Engineers Comments Regarding Surface Water Drainage

Application Reference:	Y/13/26/HH	Reviewer Reference:	ADC/KW/PC
Planning Officer:	Silvie Steiningerova	Date of Review:	08/04/2026
Site Name:	Longacre, Maypole Lane, BN18 0DR		
Application Description:	Proposed oak framed carport to northern end of existing dwelling.		
Assessment Number:	1 of 1

PROPOSED PLAN AND ELEVATIONS

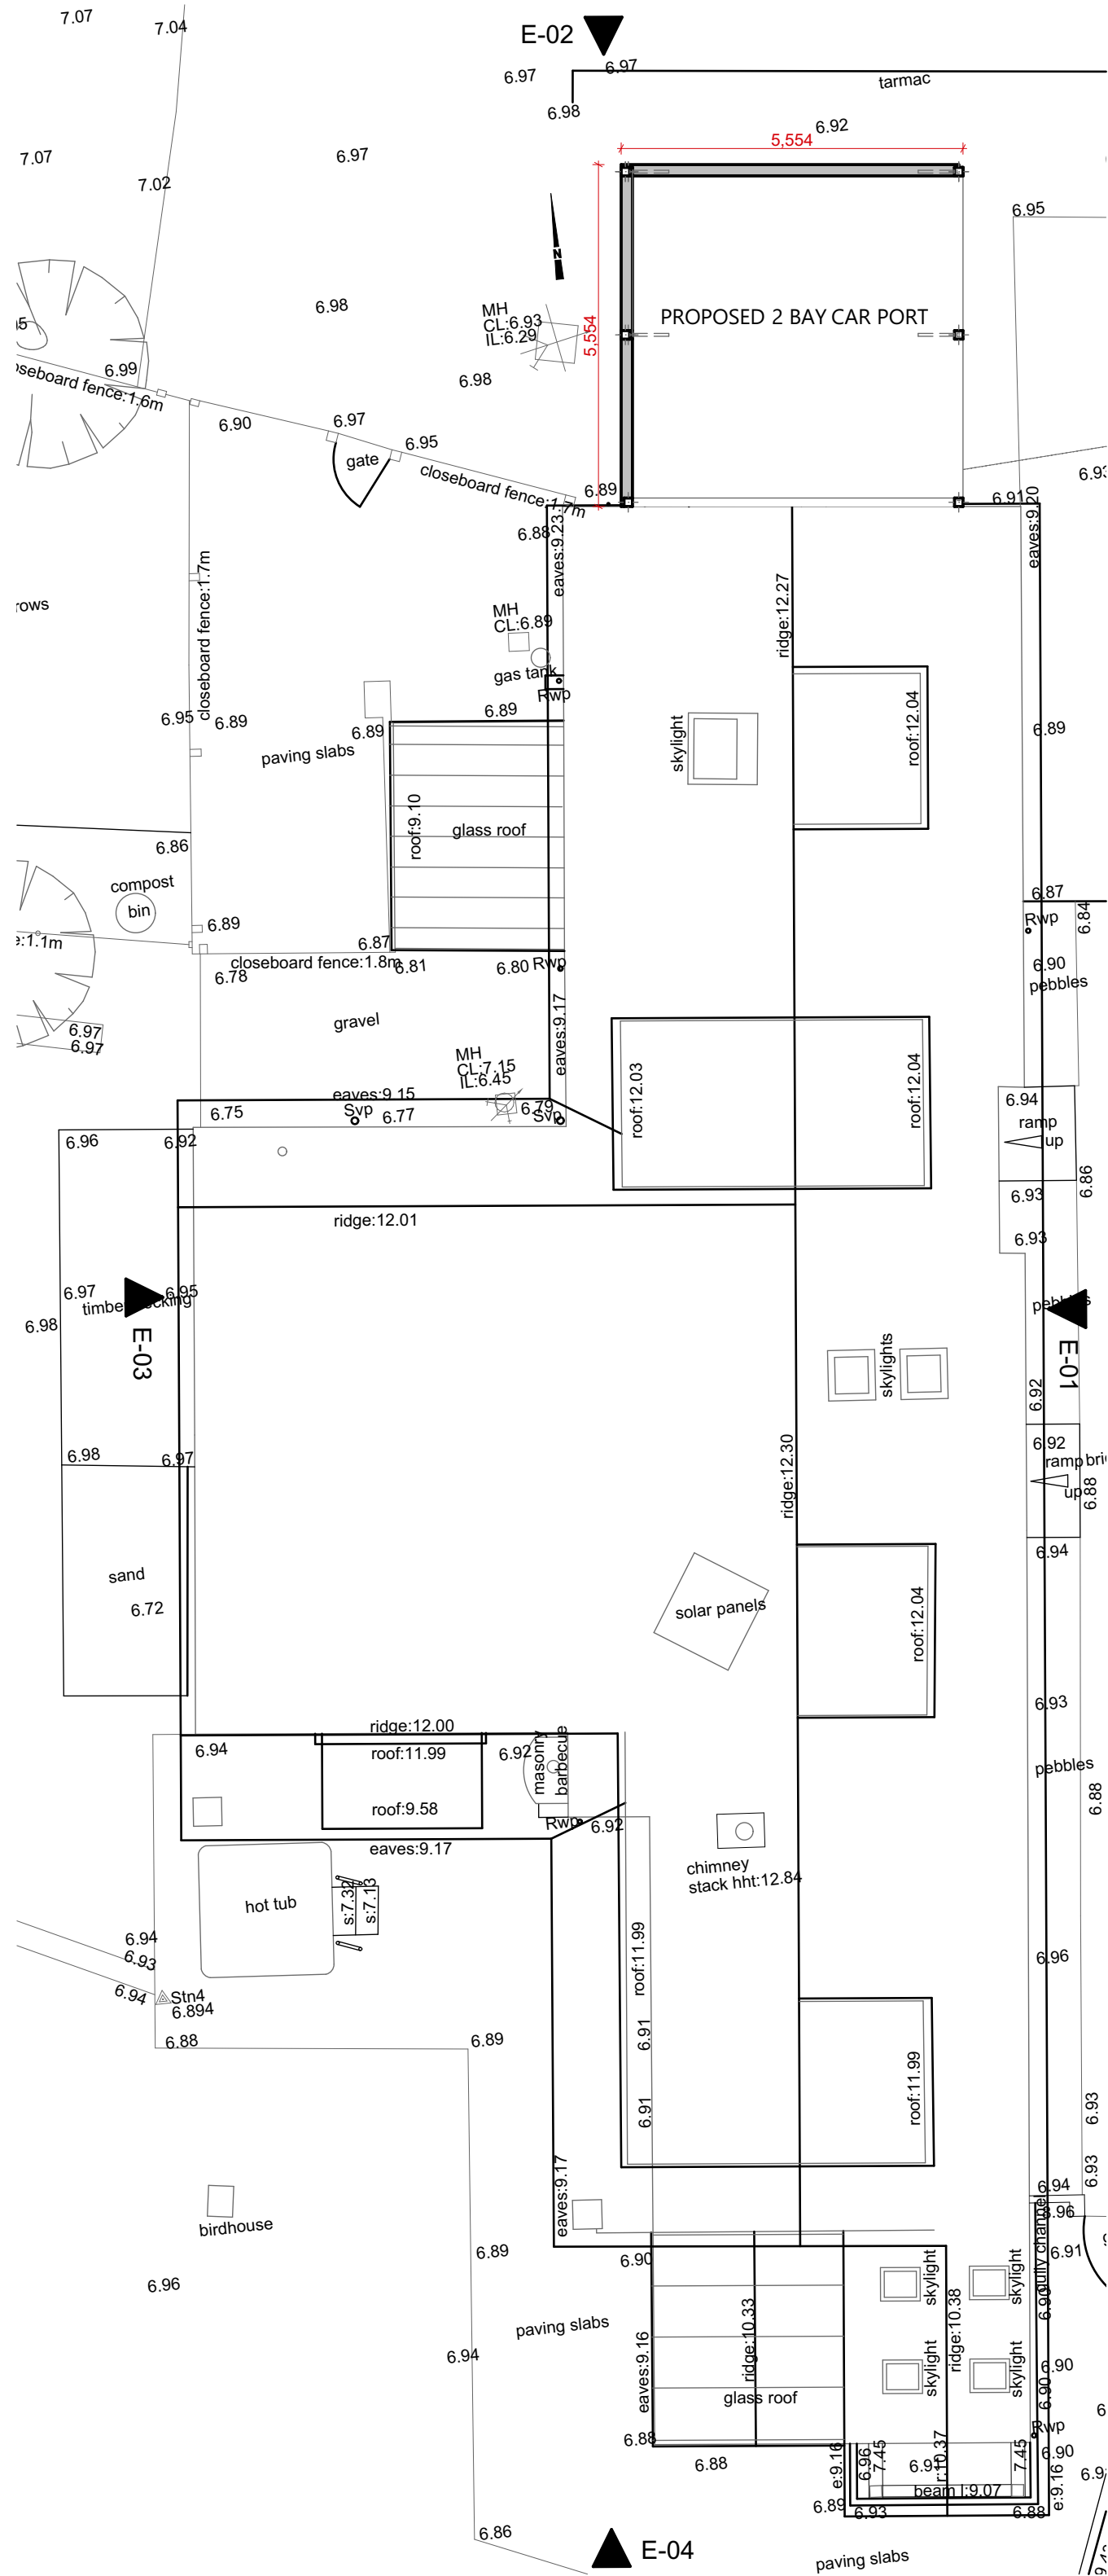
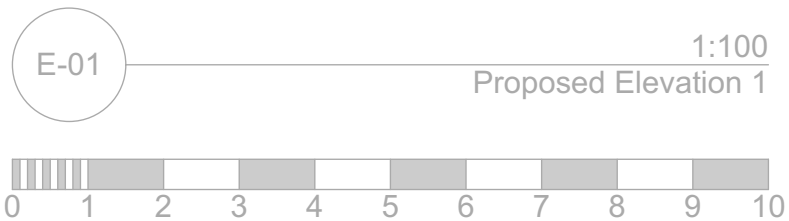
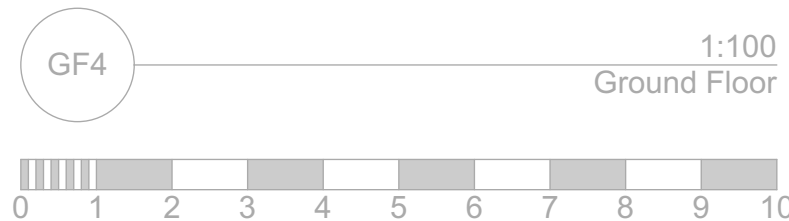
- 1.1. It is proposed to discharge the surface water to the existing drainage system, however no details have been provided to indicate what this system comprises of, or to provide capacity check for this system. A confirmed discharge location is required by Standard 1 of the Non-Statutory Technical Standards for SuDS (NSfS). As insufficient evidence has been submitted to demonstrate how the applicant intends to drain surface water, we are unable to assess whether the proposed

development would increase flood risk. It is the responsibility of the applicant or their drainage designer to provide this evidence. For this reason, **we object** to the proposal, as the submission of such evidence may affect the scale and layout of the development.
